Consultation Response from KC, Highways Development Management (HDM)
2023/93503 Land off Roslyn Avenue, Netherton, Huddersfield, HD4 7EW
Outline application for residential development of 82 dwellings and associated works, with layout and access as considerations.
Date Responded: 23/04/24
Responding Officer: A Darwin
Responding Ref: 3-24/14
RECOMMENDATION: No objection, subject to conditions
Development Overview:

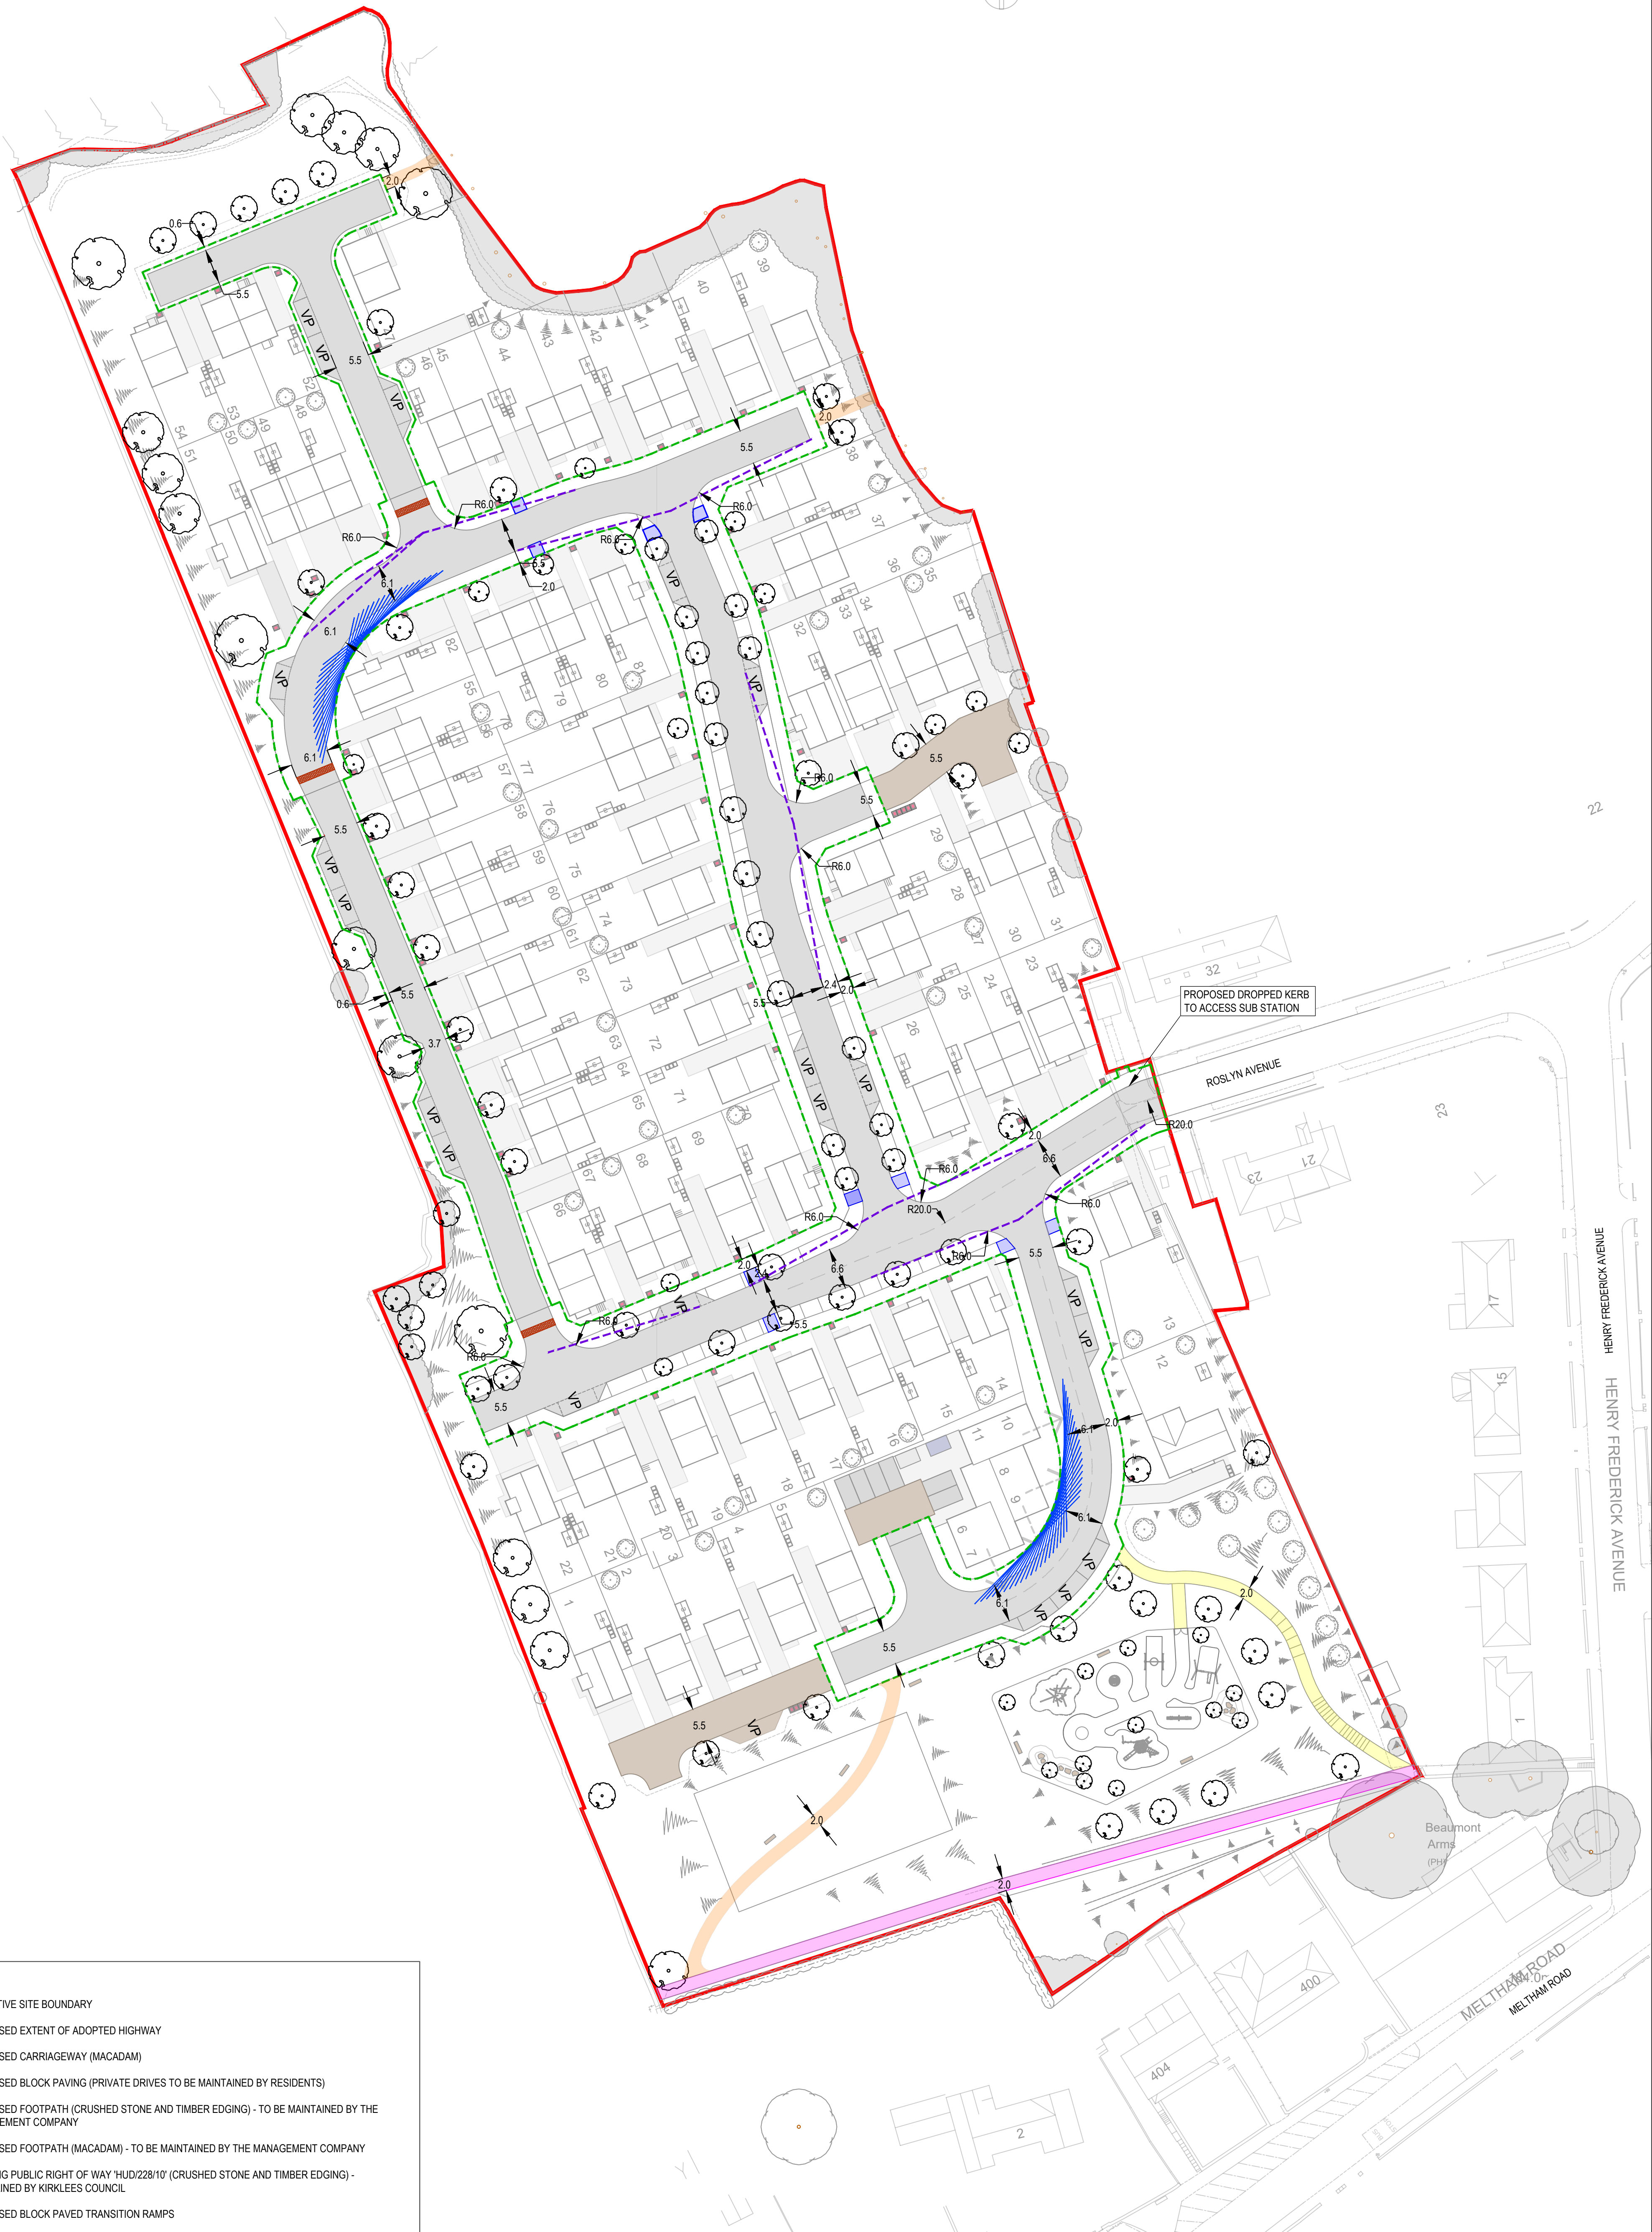
Prior to above ground works commencing, notwithstanding the information shown on drawing 23046/IN/20/A and 23046/GA/01, full details of the permanent site access works and the road marking improvements at the Roslyn Avenue / Henry Frederick Avenue junction shall be submitted to and approved in writing by the Local Planning Authority. The scheme shall include details of vehicle swept paths for a 11.85m refuse vehicle, sight lines, treatment of visibility splays, road markings, signage, crossings, construction specifications and details, levels and sections, kerbing, drainage, surface finishes and street lighting, and independent road safety audits covering all aspects of these works. Unless otherwise agreed in writing by the Local Planning Authority, the development shall not be brought into use until the approved works have been fully implemented.

Prior to above ground works commencing, notwithstanding the information shown on drawing 23046/IN/20/A, a detailed scheme for the proposed internal estate streets to an adoptable standard, shall be submitted to and approved in writing by the Local Planning Authority. The scheme shall include details of vehicle swept paths for a 11.85m refuse vehicle, sight lines, treatment of visibility splays, road markings, signage, crossings, construction specifications and details, levels and sections, kerbing, drainage, surface finishes, street trees and street lighting, and independent road safety audits covering all aspects of these works. Unless otherwise agreed in writing by the Local Planning Authority, the development shall not be brought into use until the approved works have been fully implemented and maintained thereafter.
